ENG-SP20008-R5-PrelimPlan-redlines.pdf Markup Summary

PRELIMINARY SITE PLAN

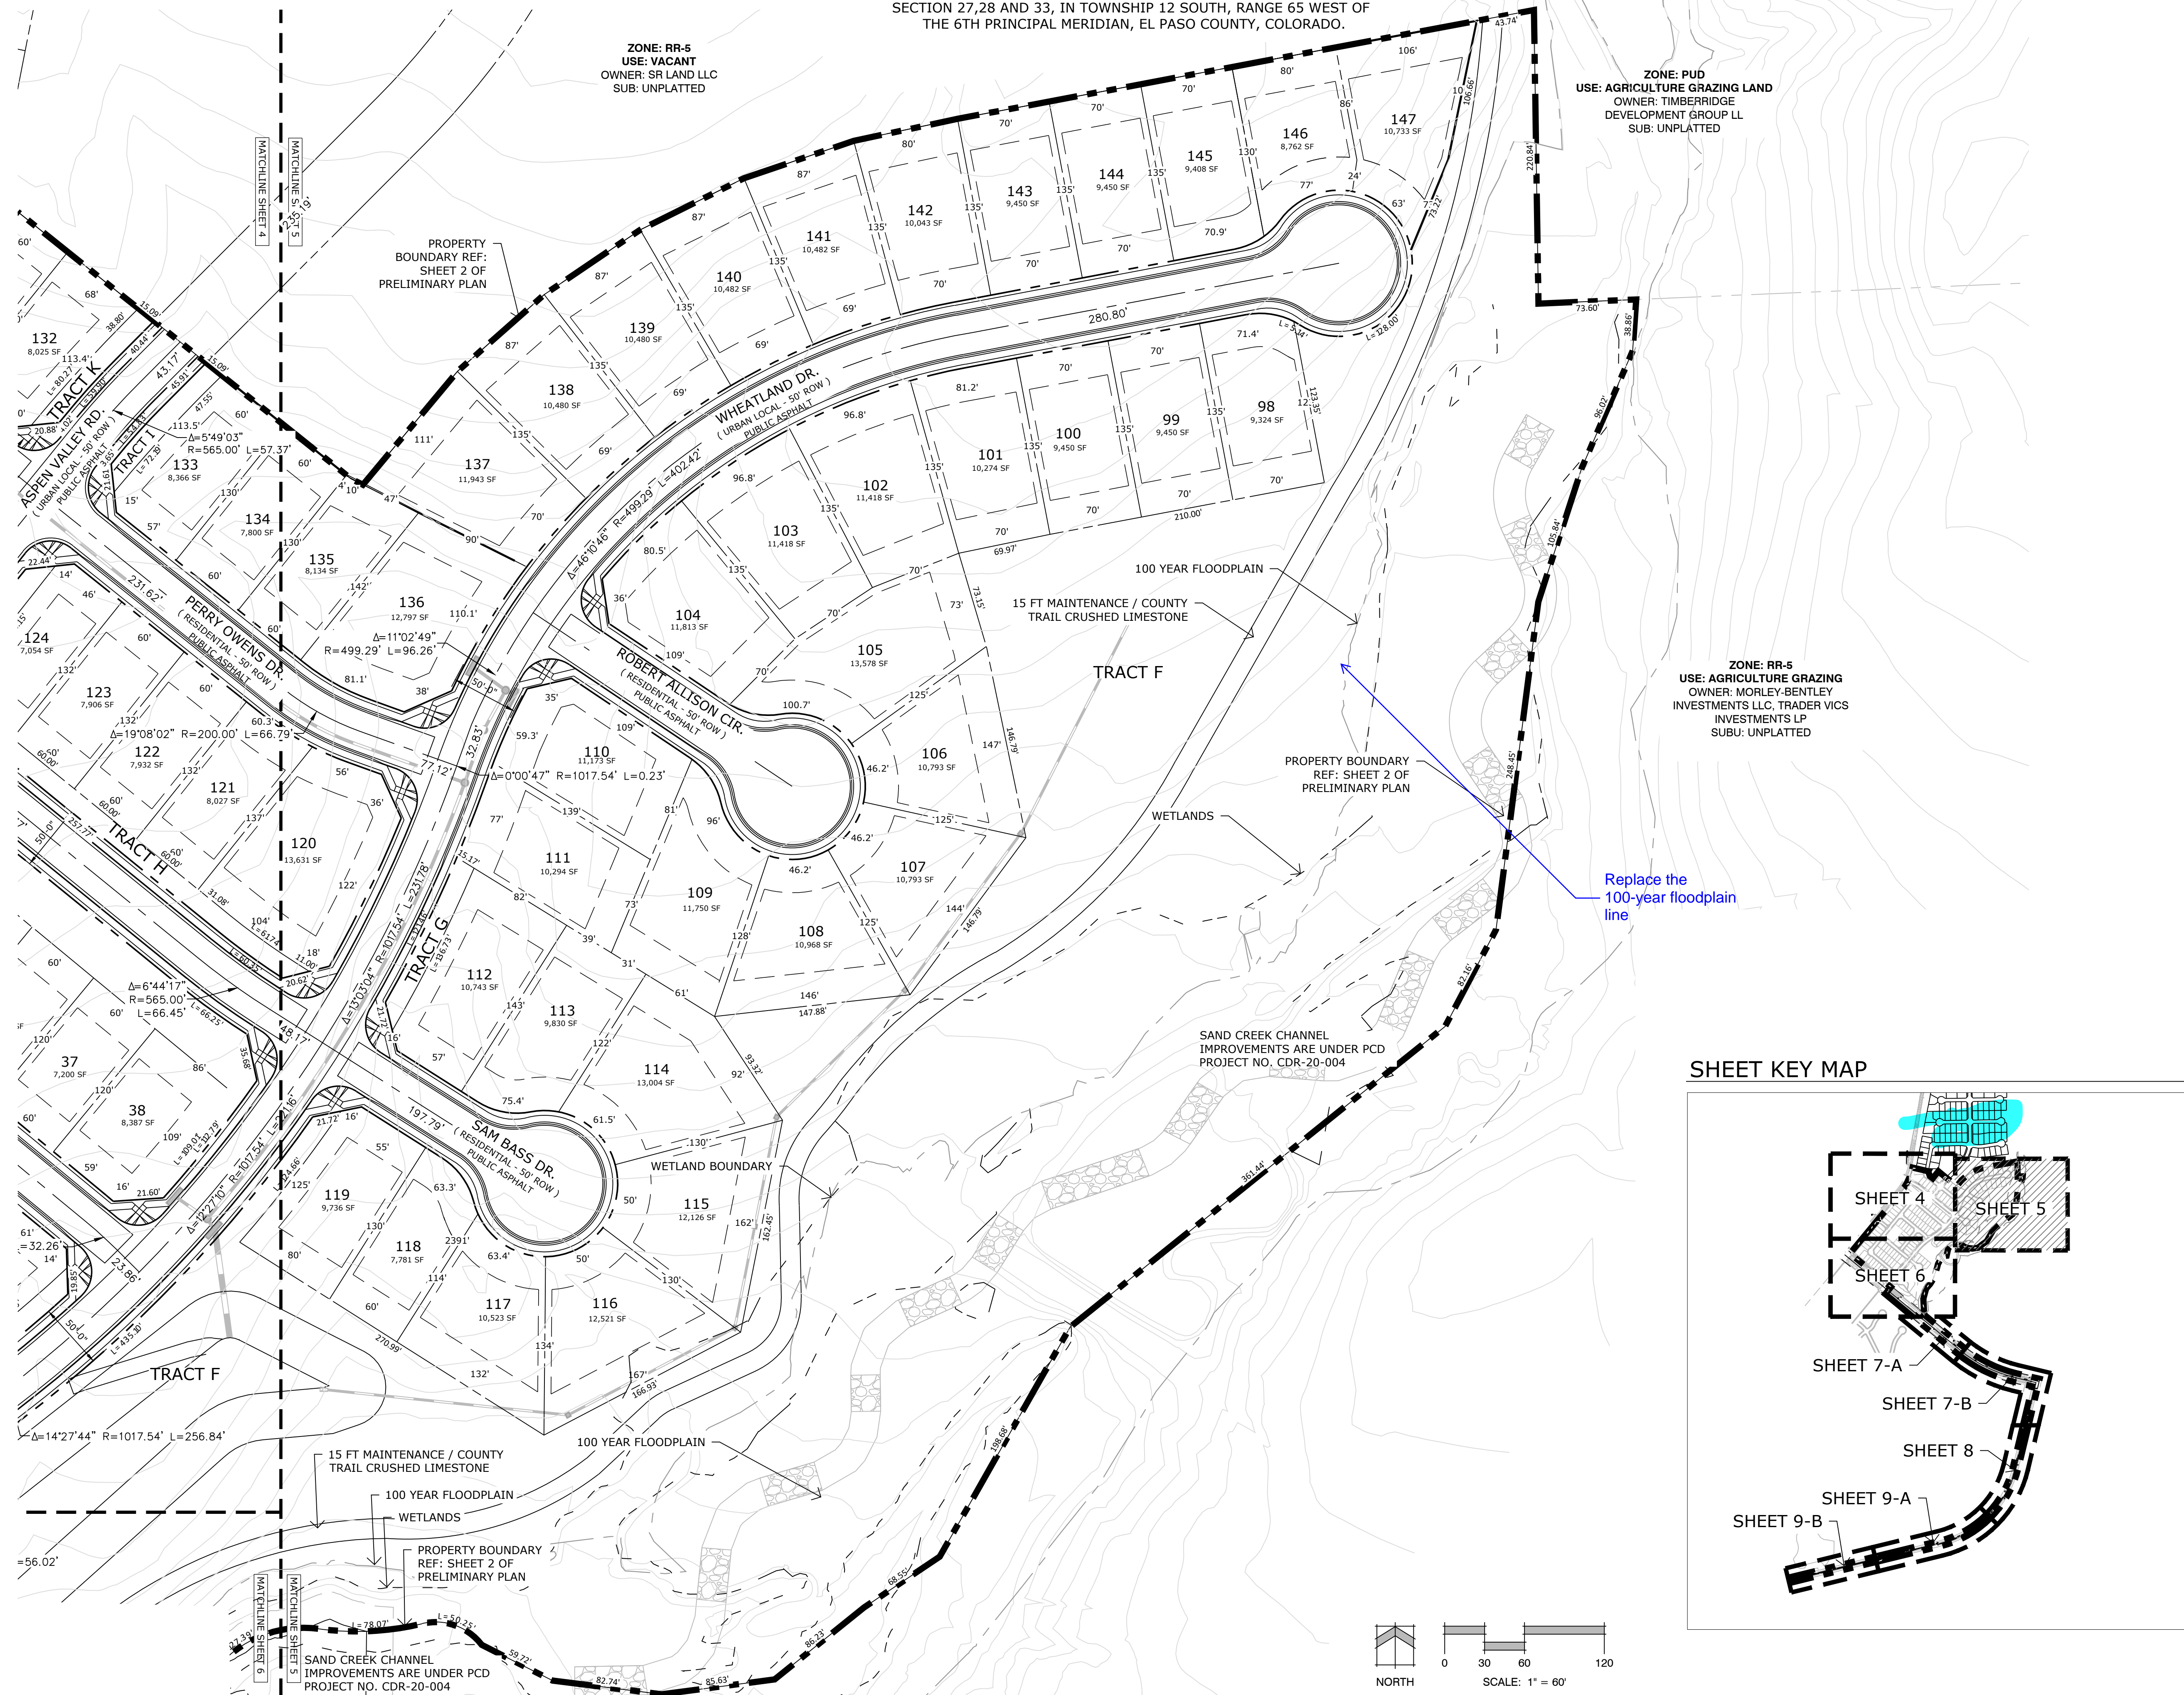
Label as Existing or proposed ROW

Turn off future lots and roads (all sheets affected)

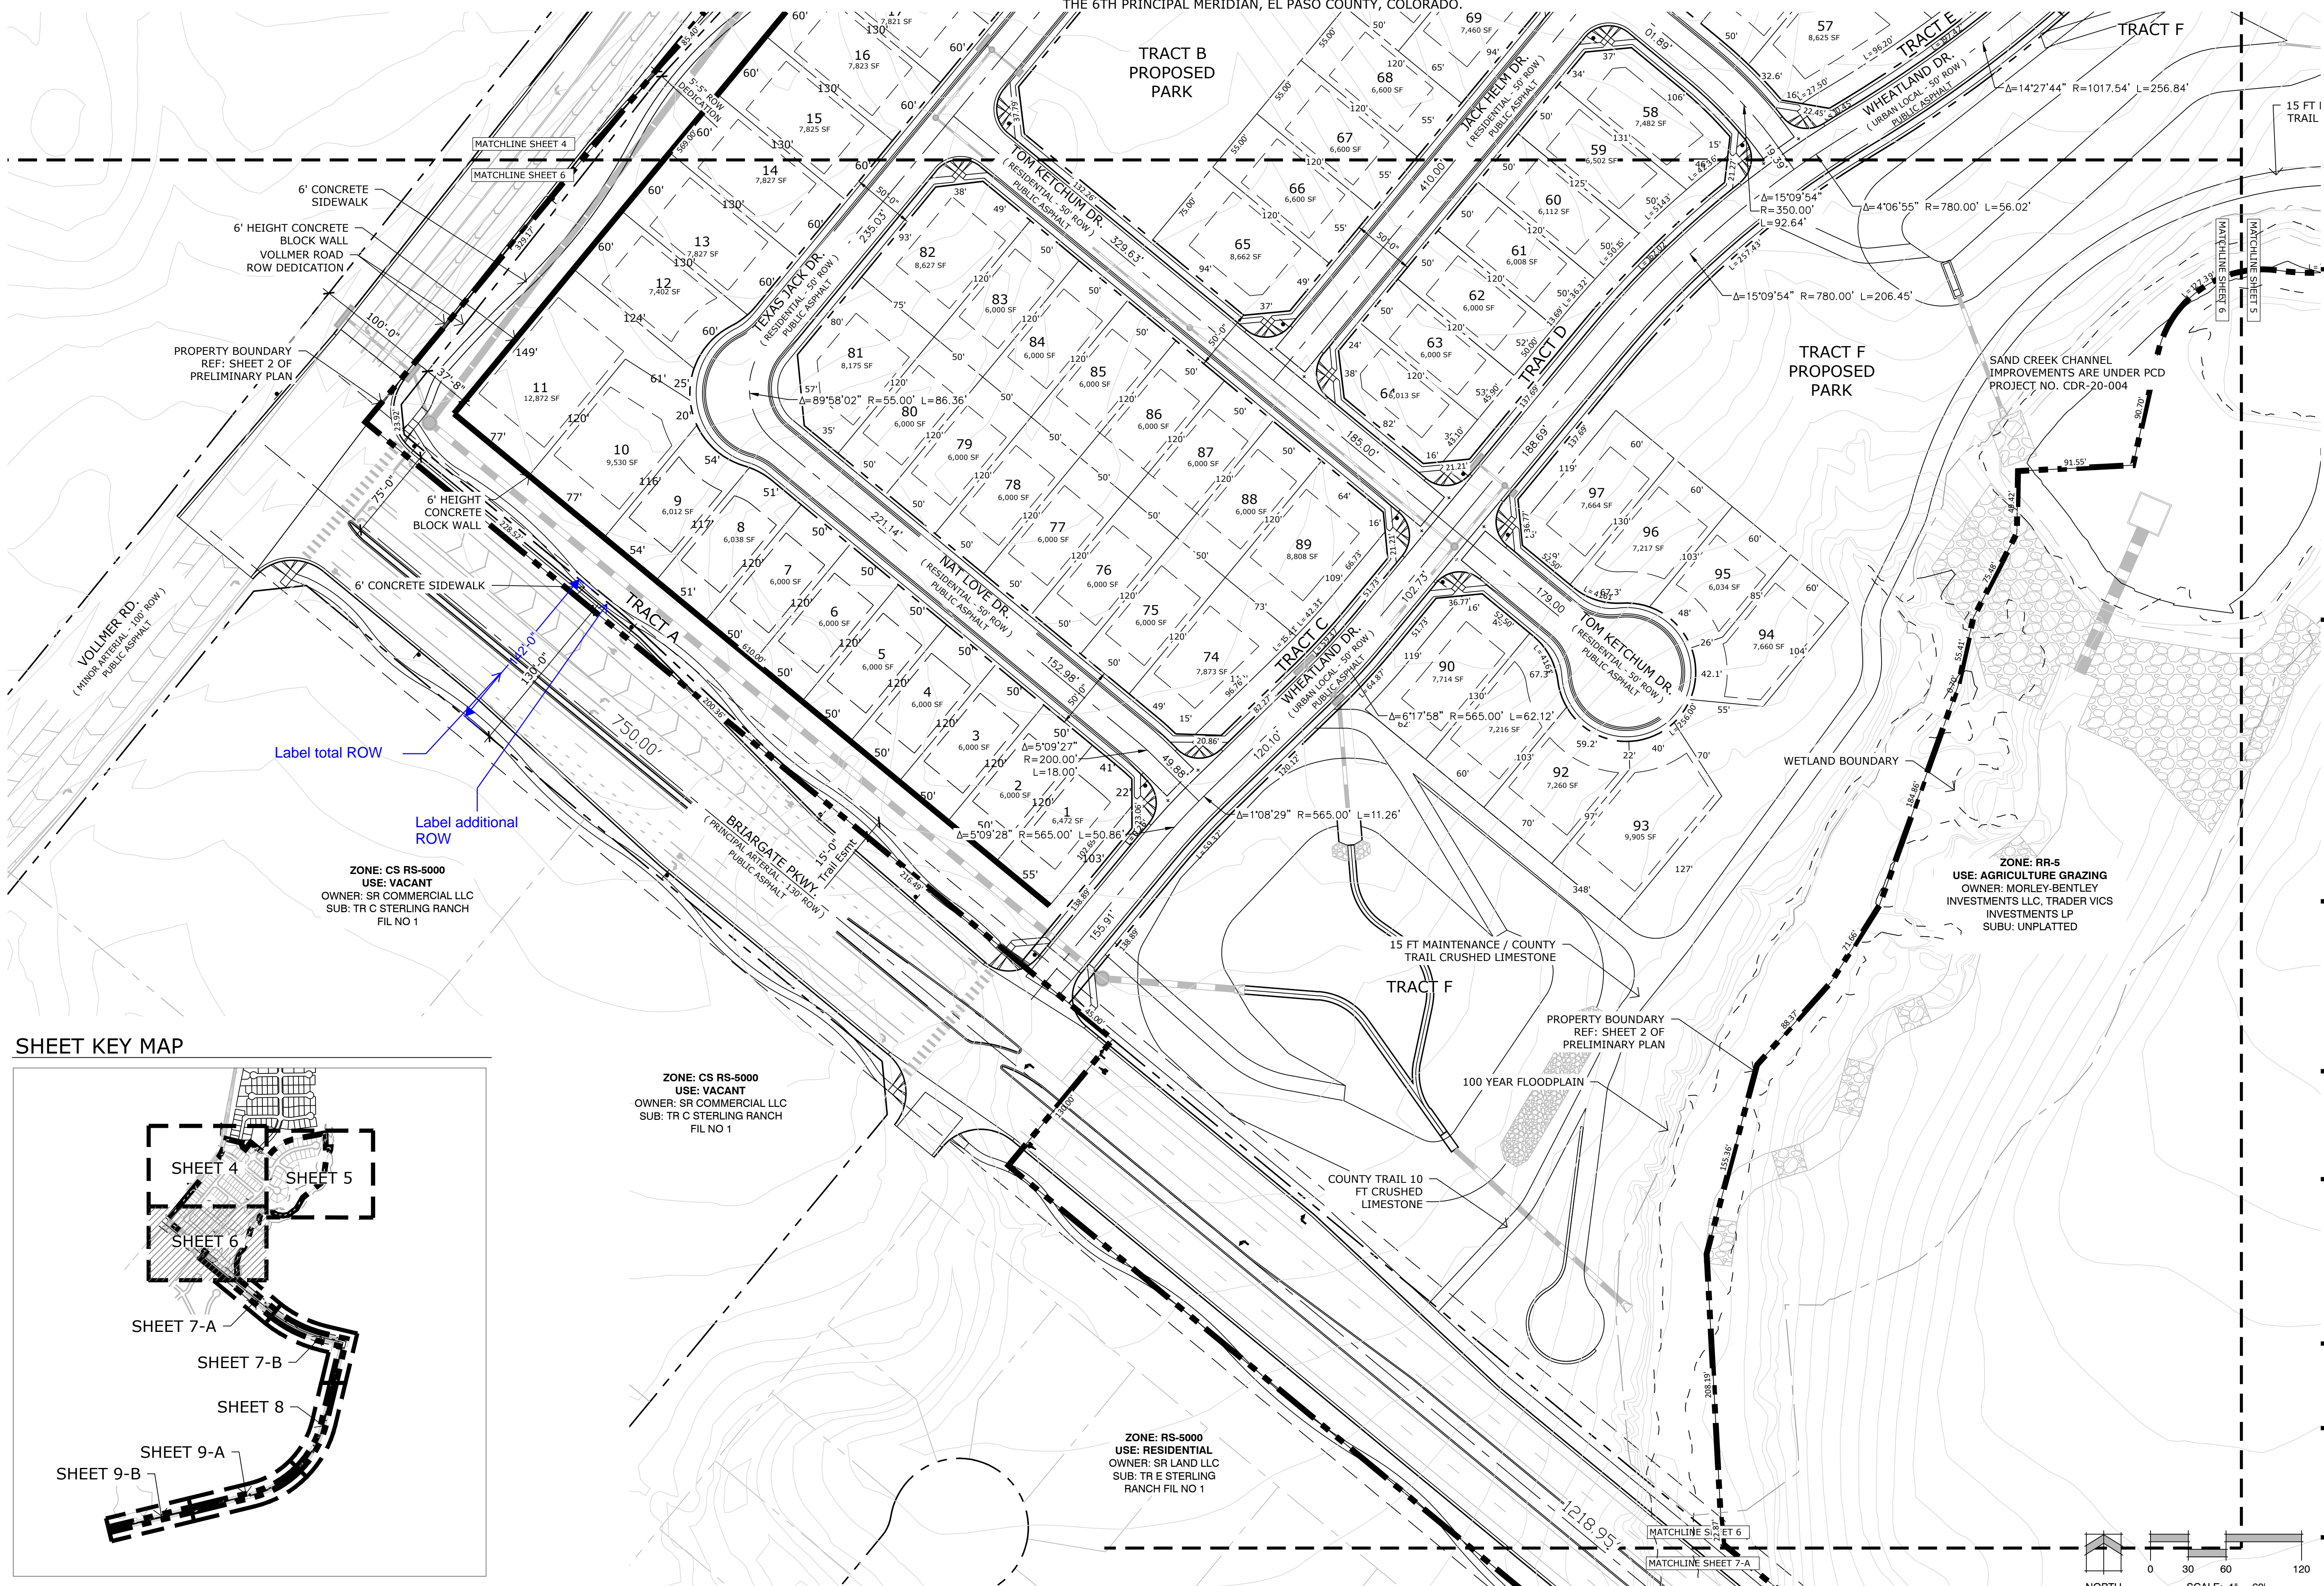
Label additional ROW

Label total ROW
